From: Franklin, Richard [REDACTED]
Sent: 27 November 2019 13:02
To: Planning.Responses [REDACTED]
Cc: Planning SE [REDACTED]; Bown, Kevin [REDACTED]; Bowie, David [REDACTED]; Cleaver, Elizabeth [REDACTED]
Subject: FAO Mr K Roberts: Highways England response (our ref 85502) re. A/100/19/PL - Arundel Acre

For attention of:	Mr K Roberts
Site:	Arundel Acre, Arundel Road, Angmering, BN16 4EU.
Development:	Change of use of land from agriculture for 3 No. travelling showpeople plots (Sui Generis) with associated storage barn, maintenance area, landscaping & infrastructure.
Your Reference:	A/100/19/PL
Highways England's Reference:	85502

RPS Drawing/Figure Number	Rev
JNY10317/01a	-

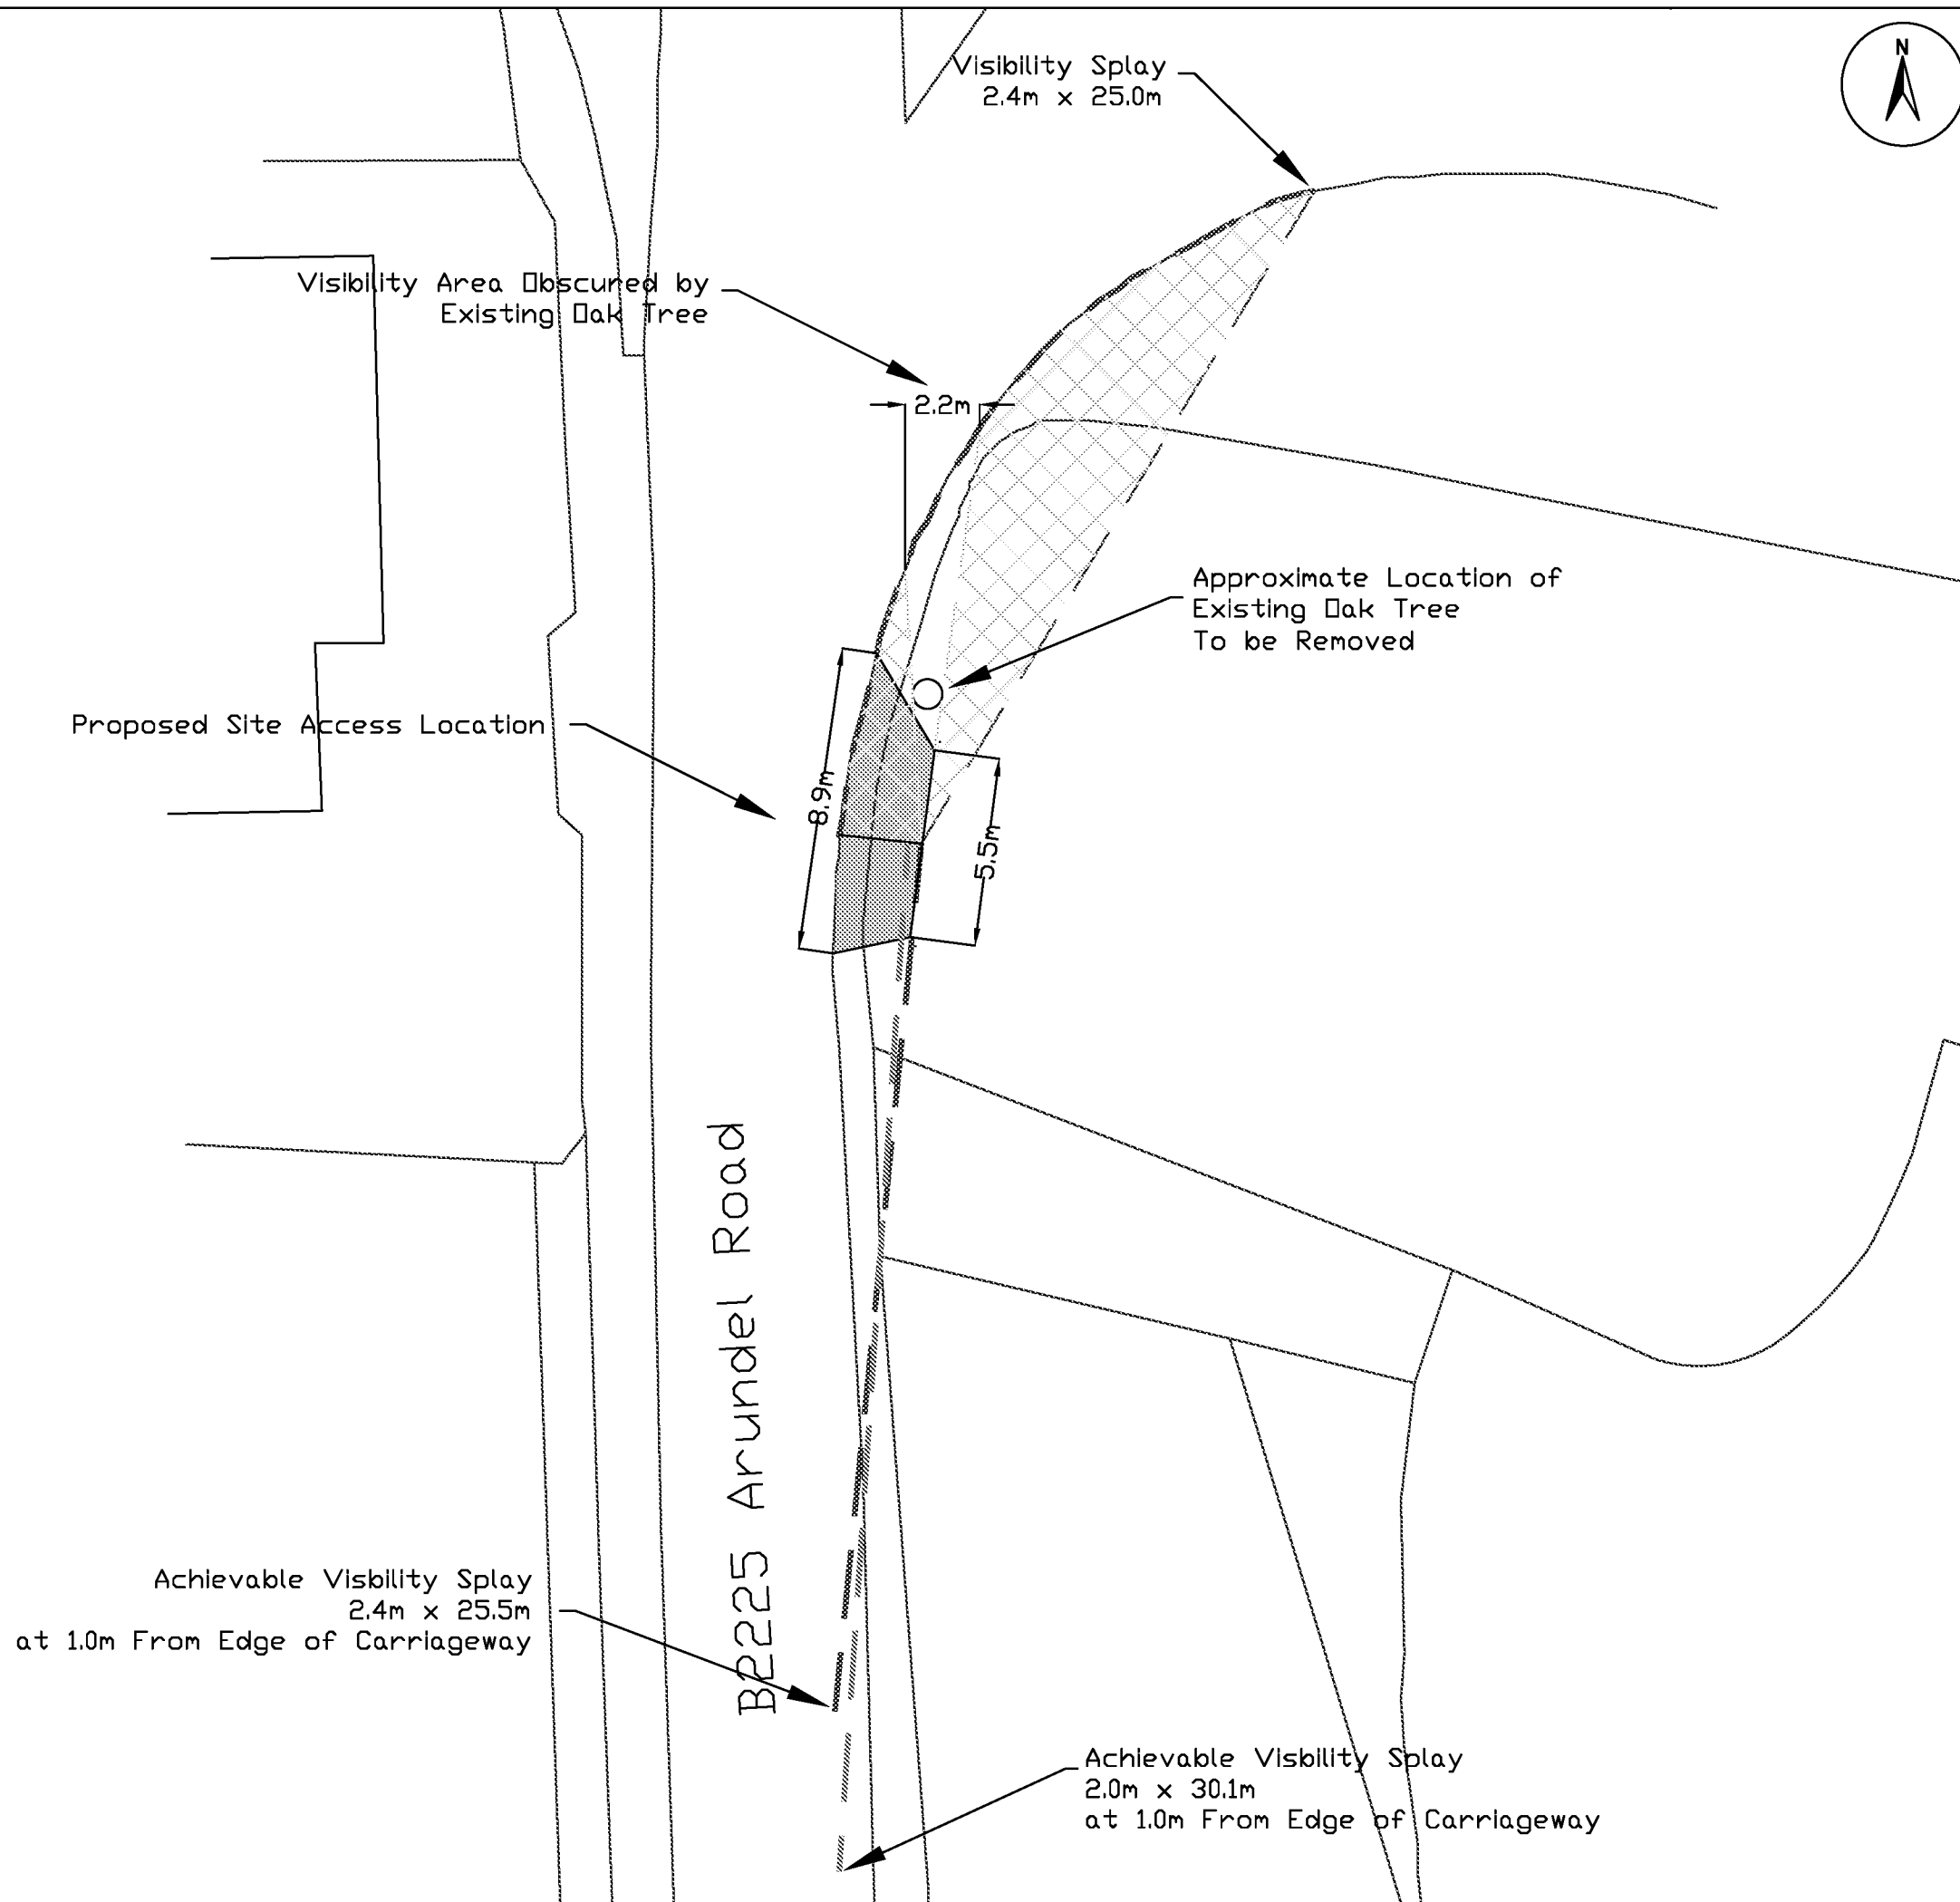
- The visibility splay assessment in the recent Technical Note and plan is based on Manual for Streets (MfS). Please note that MfS is not a recognised standard for the trunk road and particularly not in this location, and, Highways England requires the assessment to be undertaken in accordance with the Design Manual for Roads and Bridges (DMRB) as previously outlined below;

- Notwithstanding the above, the Technical Note and plan show retention of an oak tree on the northern side of the access, while there is a separate undated email outlining that the applicant intends to remove the tree. Please can it be confirmed which is correct and if

removal is proposed, please can Arun District Council confirm that removal of the tree would be acceptable?
